January 9, 2025

RE: Redemption Outreach Center Stars Academy

Cindy Pierce, REHS
Environmental Health Section
Harnett County Health Department

Facility Floorplan

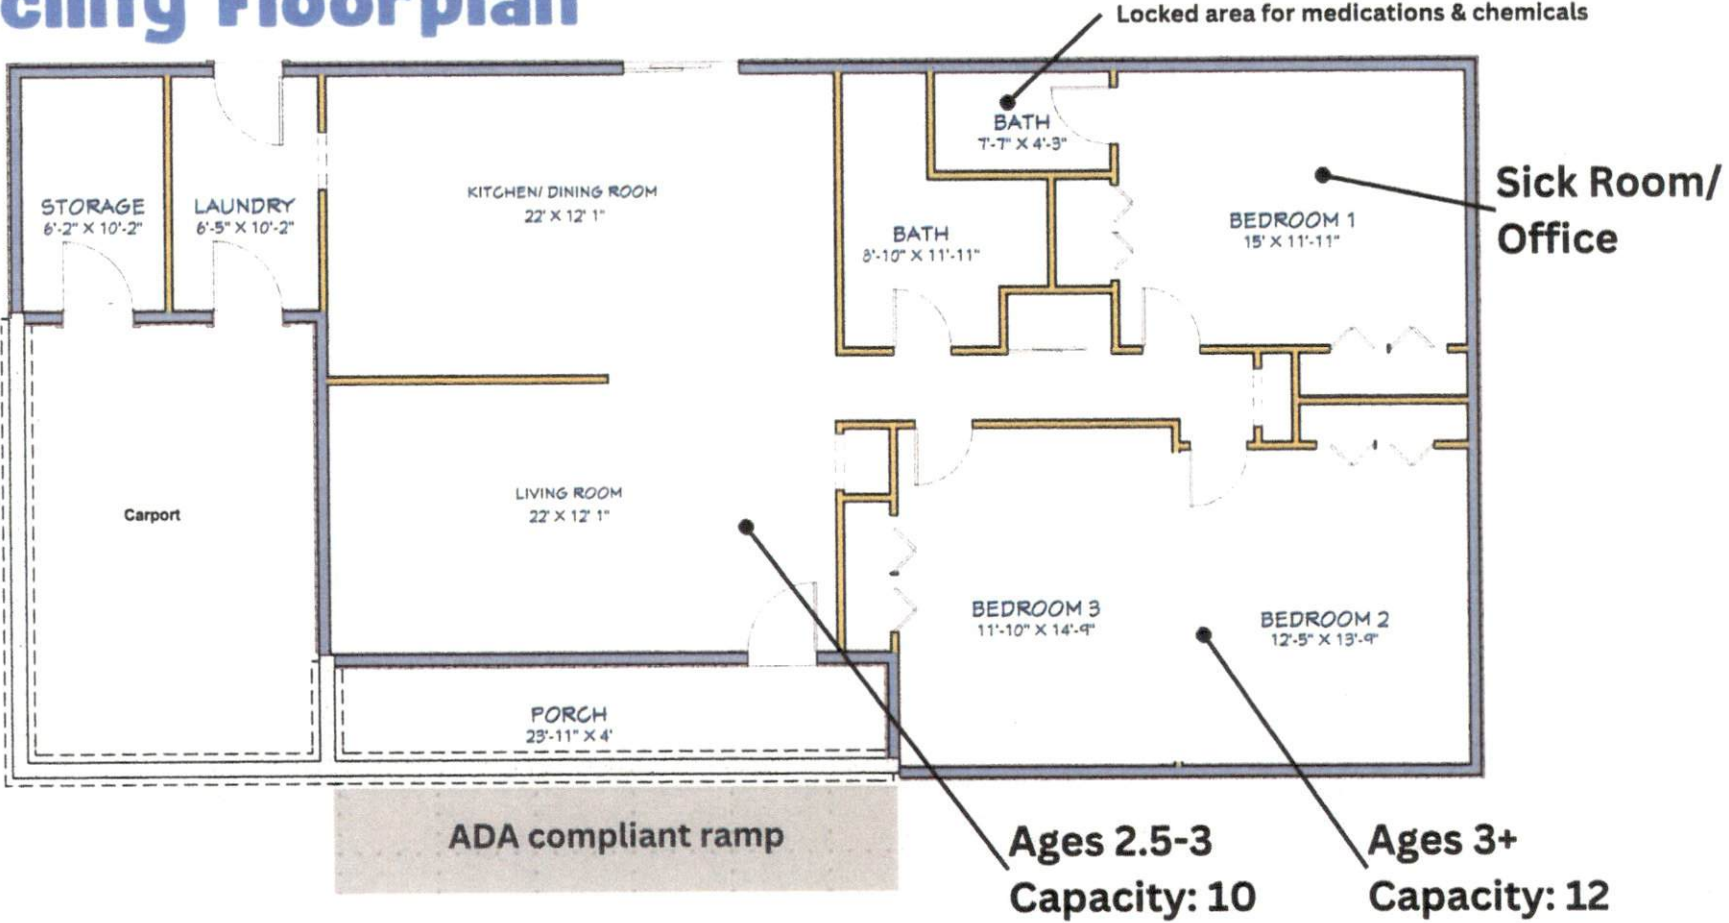
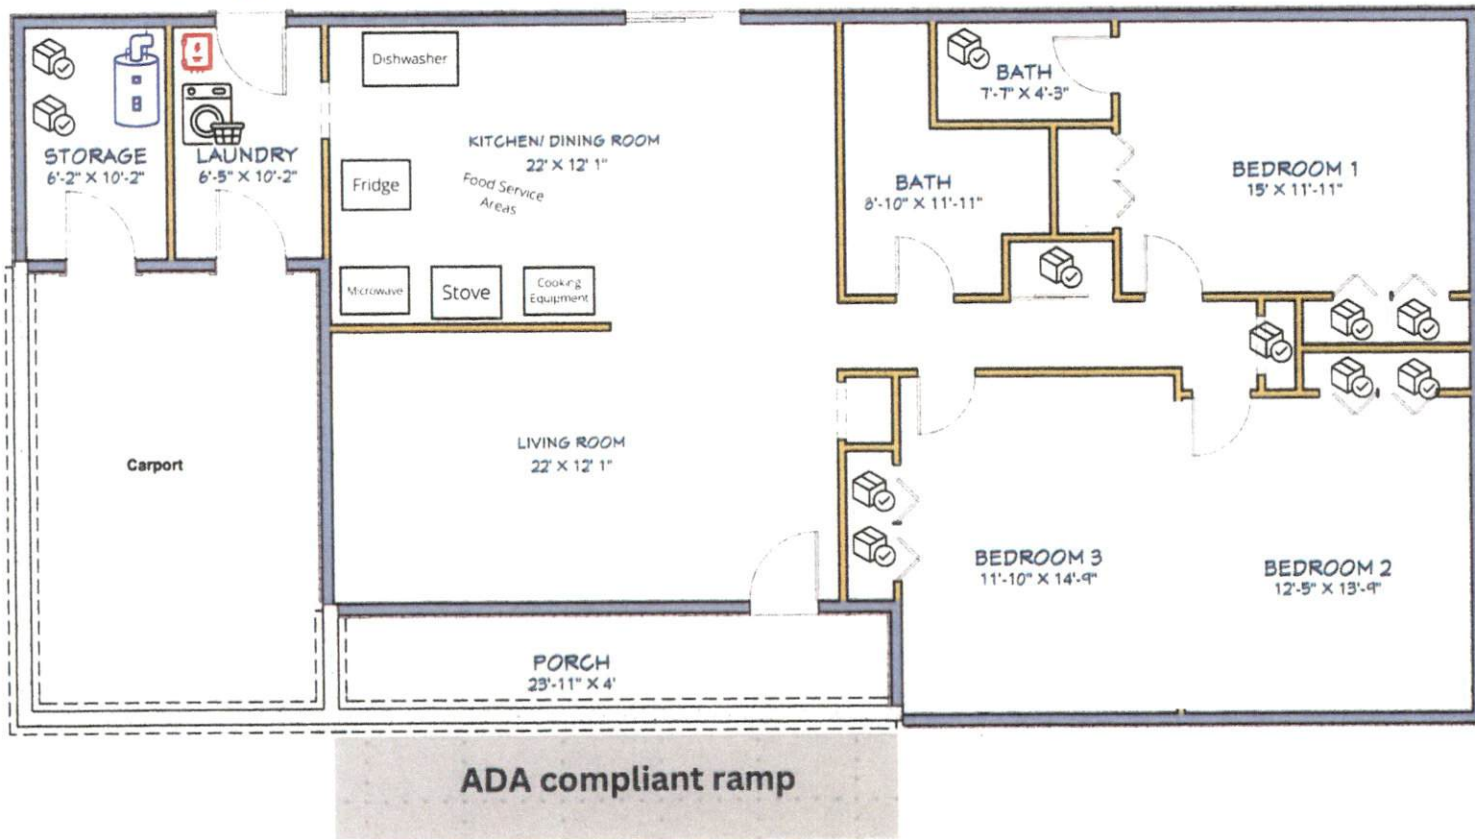
- Catered meals were listed as a food source. Please identify caterers that will be used.
- Please indicate whether the dish machine has a sanitizing cycle.
- Floor plan layout is not detailed to show all equipment. For example, there are no sinks shown in the kitchen, the canwash facility is not shown, nor is the playground location. Please indicate location of all handsinks.
- Describe and show location of proposed barrier to separate kitchen from children.
- Dining is shown as being combined with the kitchen area on the layout however the application states children will eat in the classrooms. Please clarify which is true.

- It is unclear from the layout where cabinets and countertops are located. Drainboards and countertops provided must equal no less than 8 square feet.
